From: Gregg, Robert <Robert.Gregg@lancashire.gov.uk>
Sent: 23 June 2021 17:32
To: Laura Eastwood; Planning
Subject: Revised access details 3/2021/0276 High Trees Longsight Road Clayton Le Dale.
Attachments: 124 - 01 REV C Proposed Site Plan.pdf; 124 - 05 REV A Domestic Proposed Visibility Splays.pdf; 124 - 06 Agricultural Proposed Visibility Splays.pdf

Having recently spoken with the applicant and having those discussions put in writing by Judith, the previous highway concerns have now been satisfactorily resolved. Therefore the Local Highway Authority would raise no objection to the proposal on highway grounds, subject to the following conditions.

Client Mr and Mrs Taylor		
Project Proposed Development at Hightrees Longsight Road Clayton le Dale BB2 7JA		
Drawing Title Proposed Site Plan and Site Sections		
Scale 1:50/100/200@A1	Date Feb 2021	Drawn LFR
READ DESIGN LTD		
124 - 01c

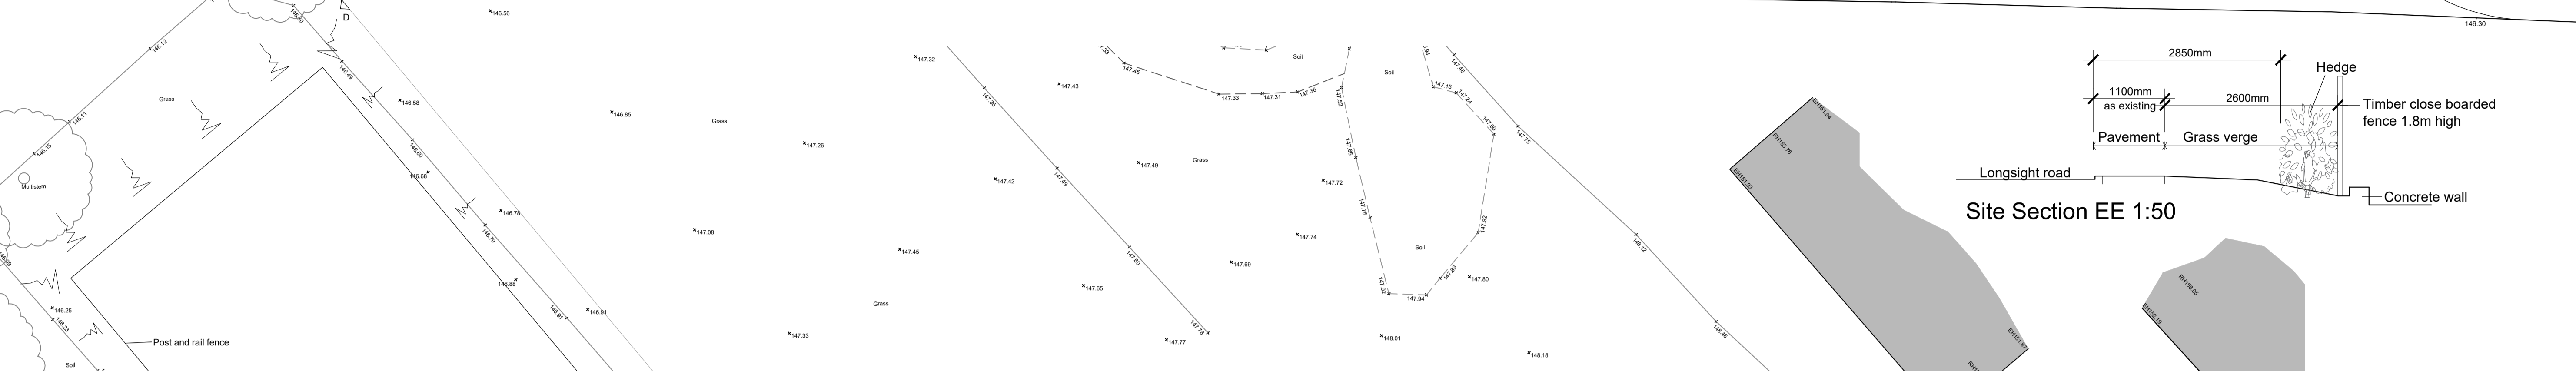
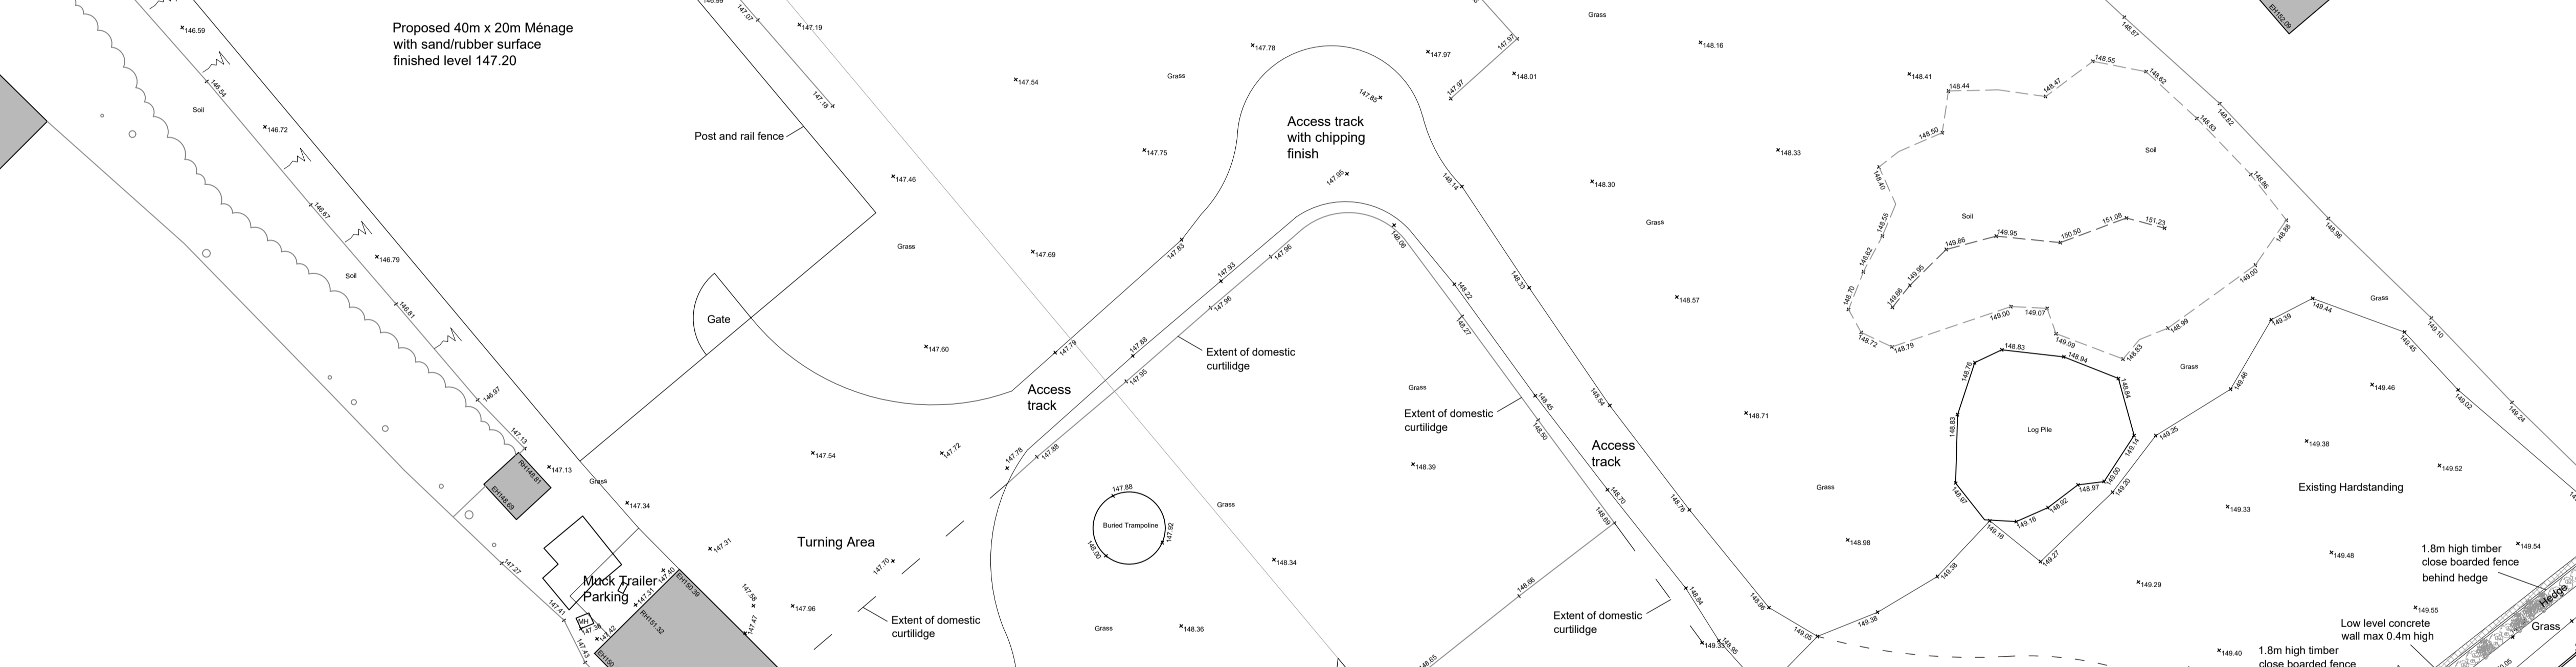
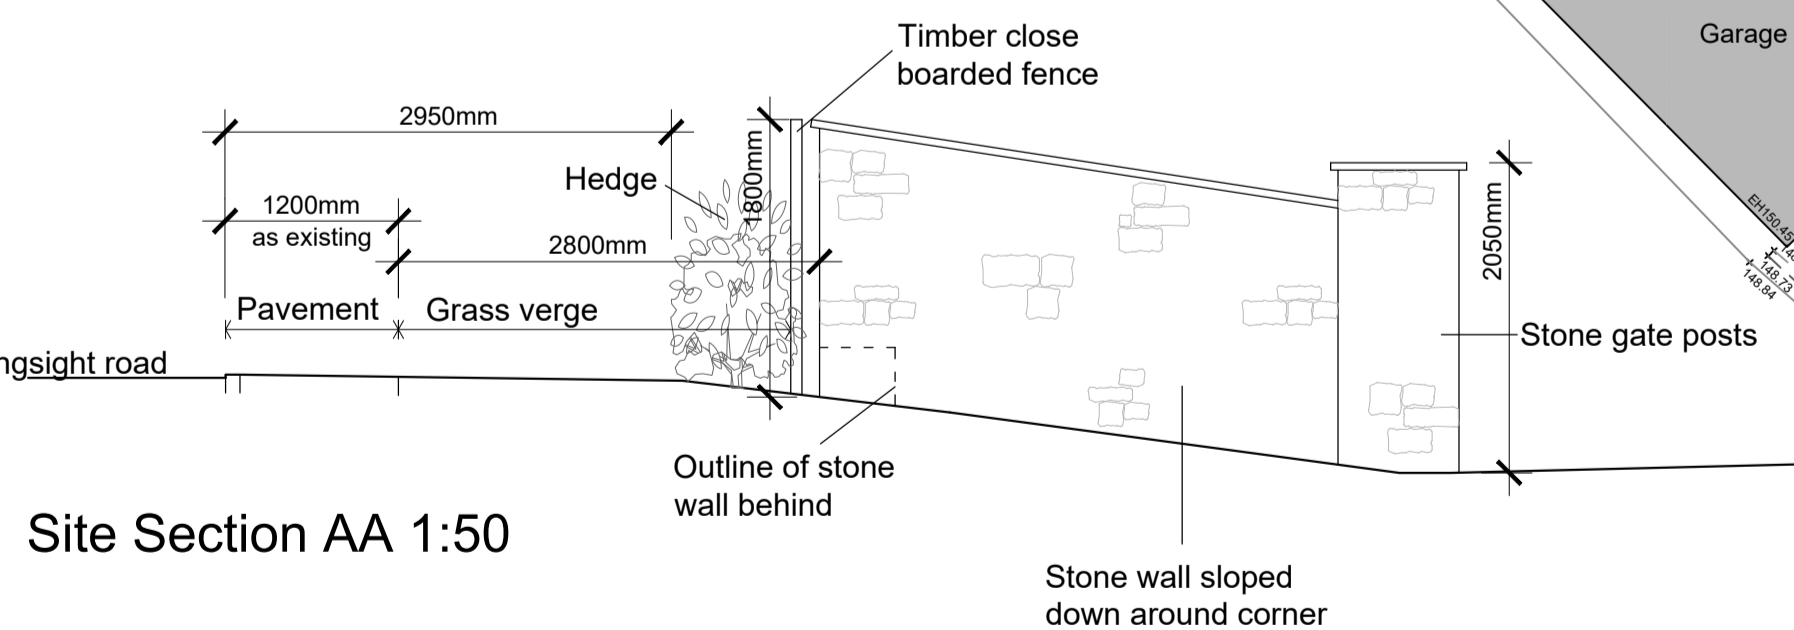
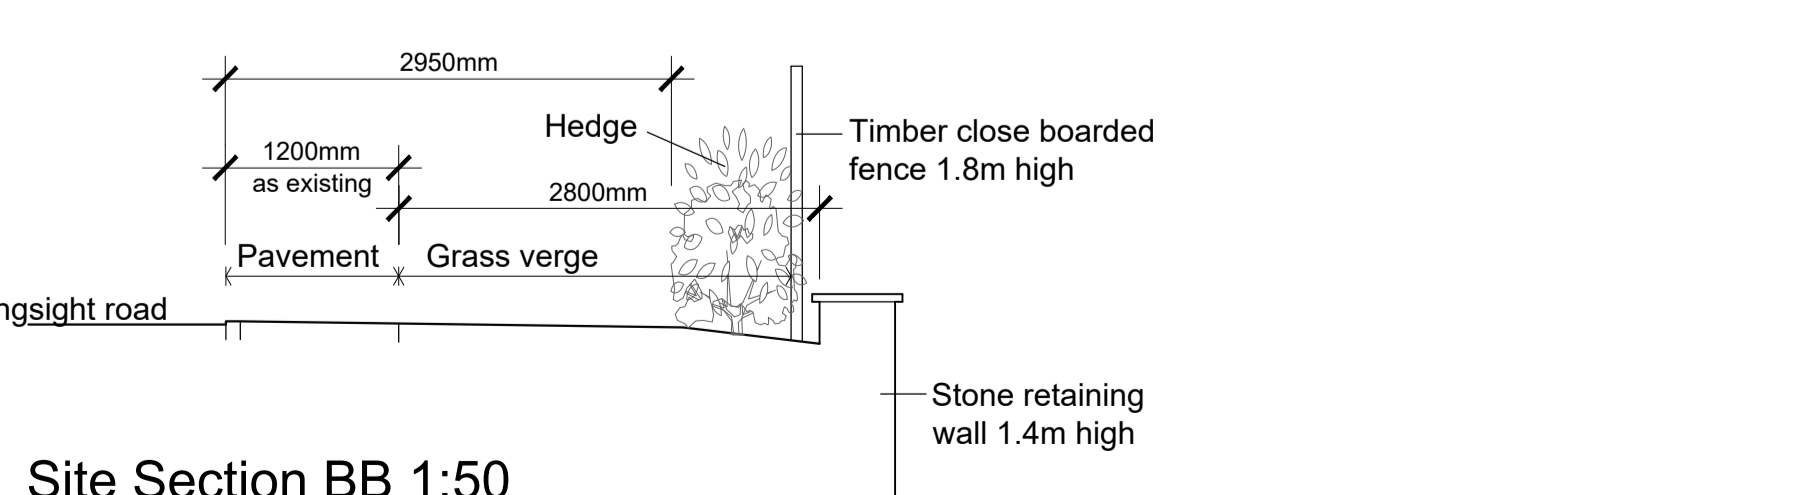
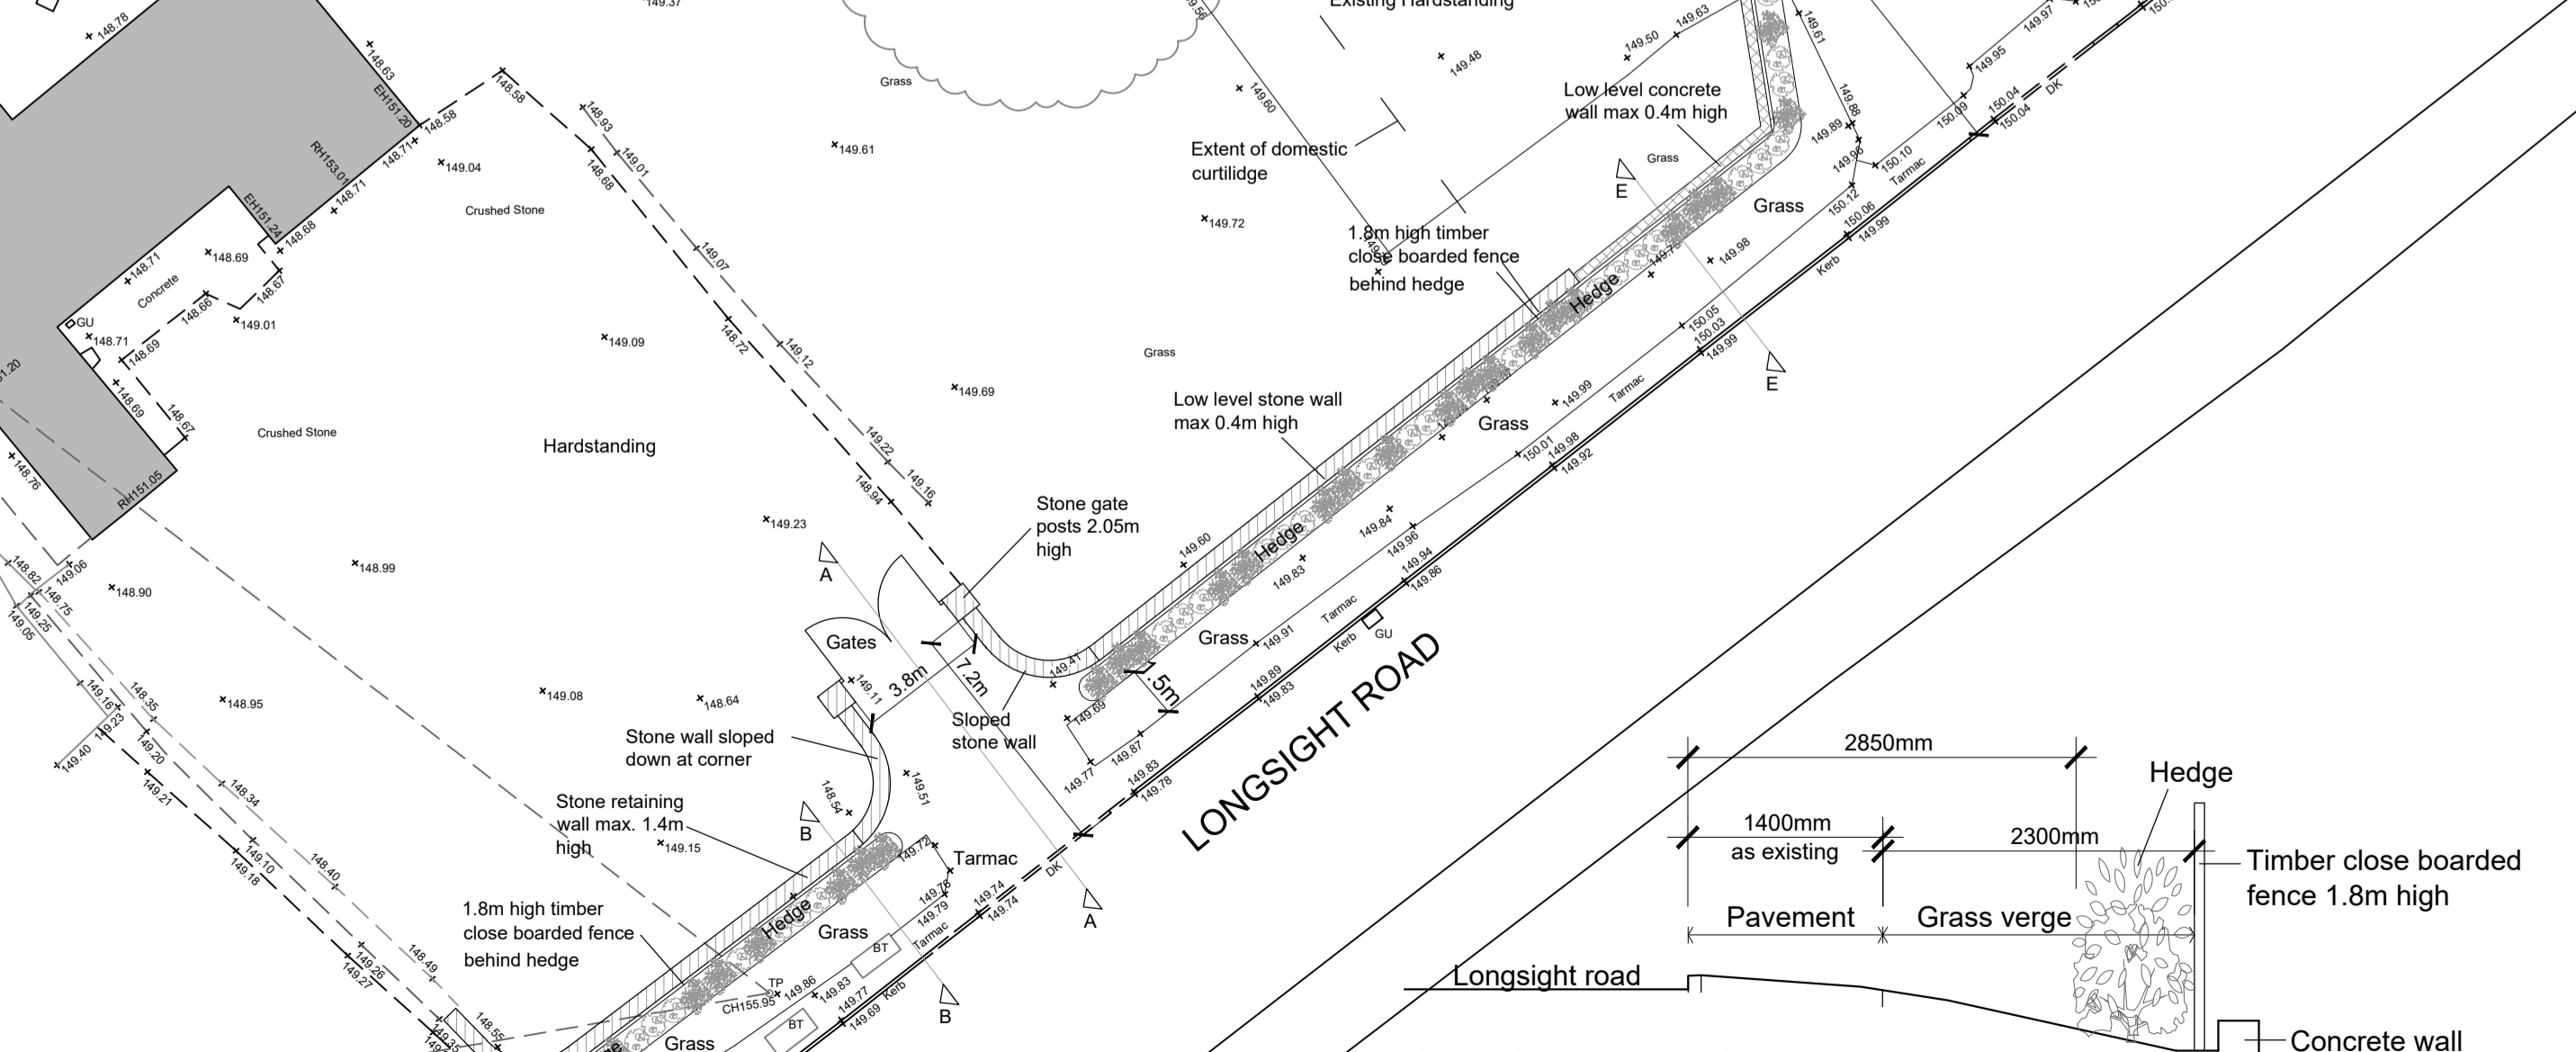
I understanding that Robert has discussed the dimensions of the agricultural access with the applicant and I write to summarise the information provided.

The hard standing area is for storage of bales and allowing enough manoeuvrability to stack and remove without any obstruction to the A59.

The majority of trips from the agricultural access will be with the applicants own vehicles for which the 8m set back for the gate is adequate. The usual maximum sized vehicle will be a single pickup. As the applicant lives on site he has control over what vehicles visit the site. If he is bringing any large vehicles or trailers back to the site he will open gates before he leaves. If any deliveries are anticipated he will leave the gates open. This is low frequency and there will be no deliveries or large vehicles visiting the site that are not pre-arranged.

The width of the gateway is to accommodate vehicles turning into to the site without the need to 'swing' across the centre line of the carriageway.

Keeping the gates set back at 8m rather than 10m retains more manoeuvring space within the site at the site for vehicles with trailers to avoid any reversing onto the A59.

2. No building (or use hereby permitted) shall be occupied (or use commenced) until sufficient visibility splays have been provided at all access points, as shown on the approved plans. Nothing shall be erected, retained, planted and / or allowed to grow at or above a height of 0.9 metres above the nearside carriageway level which would obstruct the visibility splay. The visibility splays shall be maintained free of obstruction at all times thereafter for the lifetime of the development.

3. Before the access is used for vehicular purposes, that part of the access extending from the highway boundary for a minimum distance of 5m into the site shall be appropriately paved in tarmac, concrete, block pavements, or other hard material to be approved by the Local Planning Authority.
